**RE: Truly Nolen at \_7921 Lorraine CT. NE. Albuquerque, NM 77505**

On behalf of our customer Truly Nolen, Inc. we are requesting an addendum to the existing Site Development Plan to include one sign on the East elevation of the building facing Lorraine Ct.

<b>BRIEF DESCRIPTION OF REQUEST</b>
Minor Amendment to add a sign on the East elevation to the Approved Site Development Plan to properly identify the business name.

## Sign Permit GP-2020-29829 (Applicant Revisions)

East Elevation

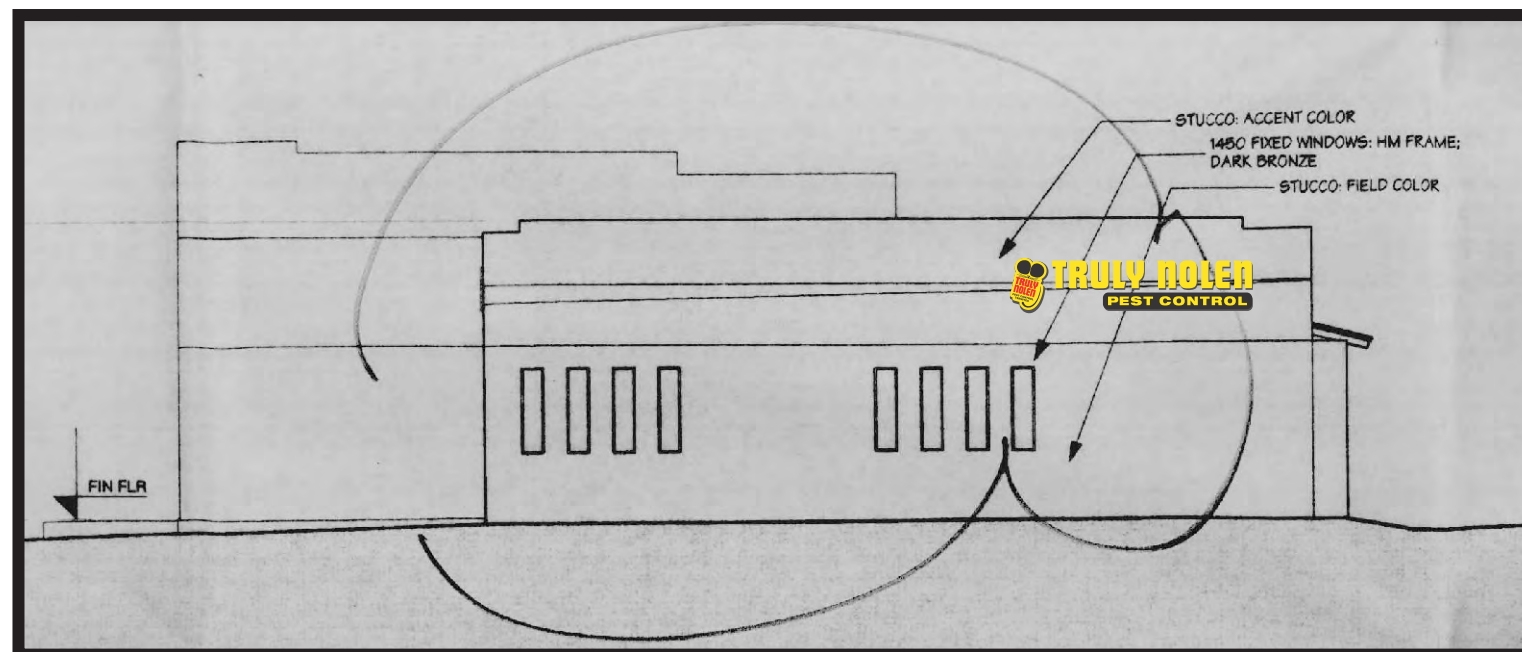
1.- Found an Approved Site Development Plan and there is not a sign called out on the East elevation provide (AA)

1.- Found an Approved Site Development Plan and there is not a sign called out on the East elevation provide (AA) Administrative Amendment

Based on the site plan and elevations, the proposed signs on the building do not give visible exposure to the business name. The freestanding sign is the only signage visible to the public on El Pueblo Road. Therefore, a sign as proposed on East elevation, will provide a clear view from both roads Lorraine Ct. & El Pueblo Rd. Please refer to the attached drawings.
